Subject: BR/229/17/PL

In the Arboricultural Impact Assessment that the applicants have had done, it states under number 4.7 that "The levels of the driveways located adjacent to the no dig parking bays will need to be raised to match. This should not be an issue particularly as the floor levels of the houses will be raised above the existing ground level.

Tree Constraints Plan and Tree Retention Plan

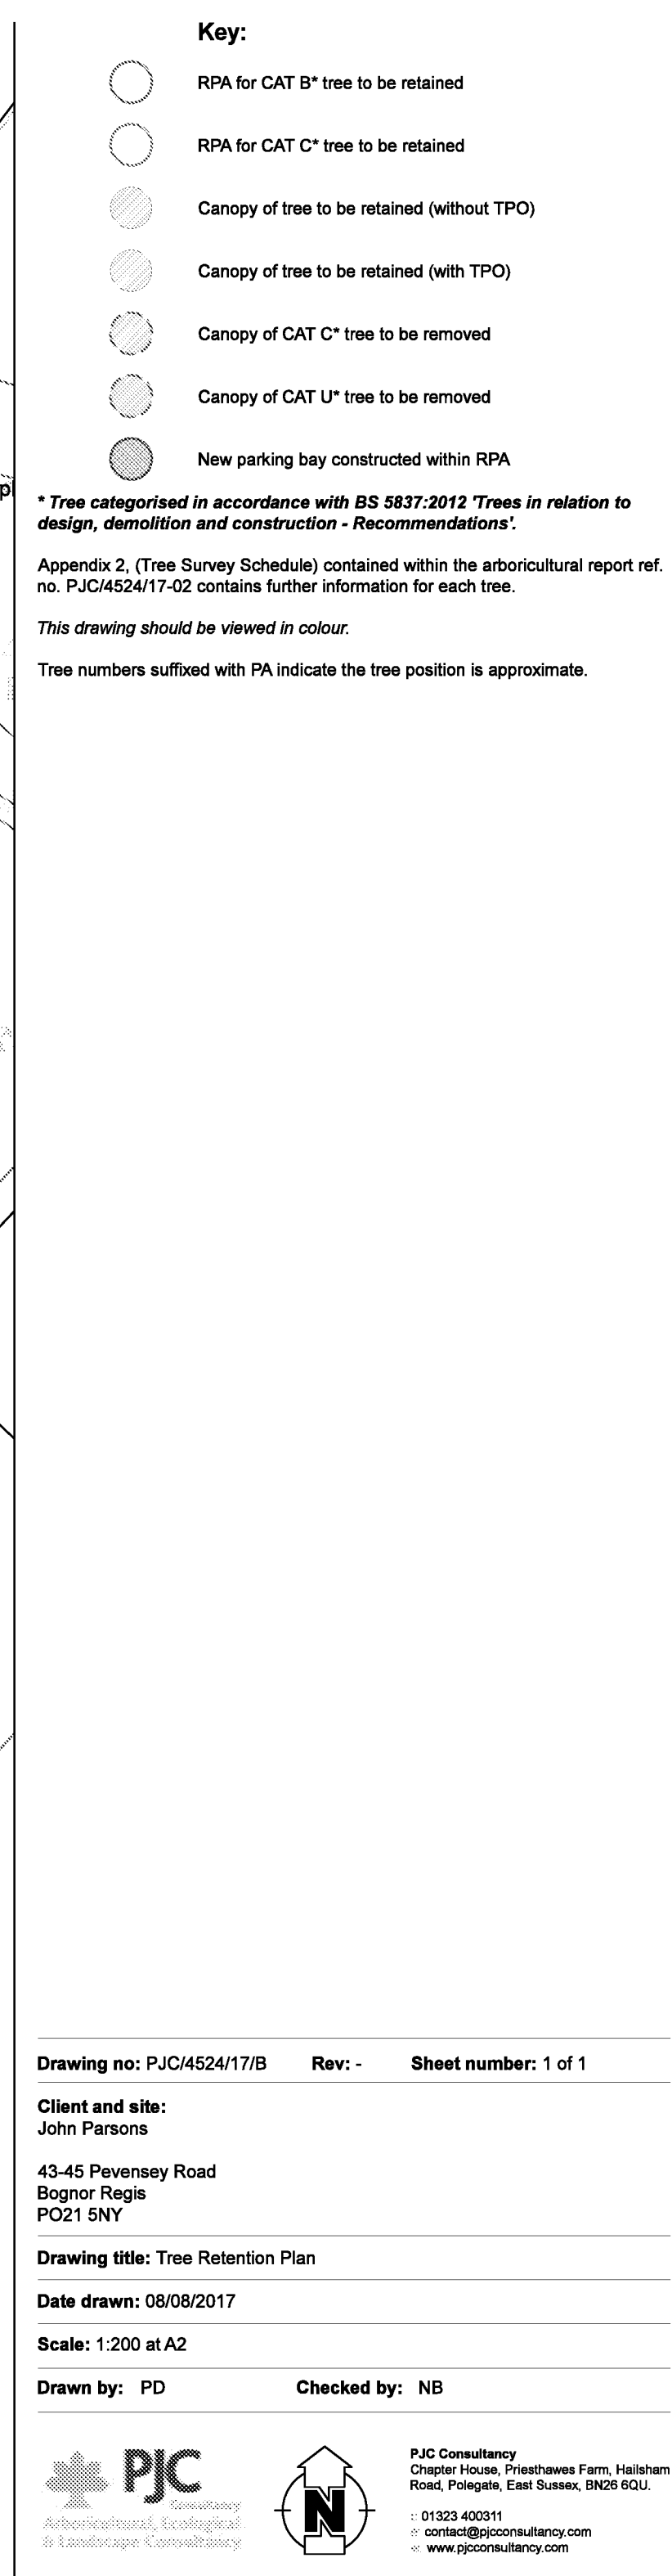
Well it will be a issue to us because this is directly behind our garden and this is the low lying area that pools with water that stops any flood water/excess heavy rain water coming into our garden, raising this is area is going to alter land levels and cause existing residents to flood.

Have you read this paragraph?
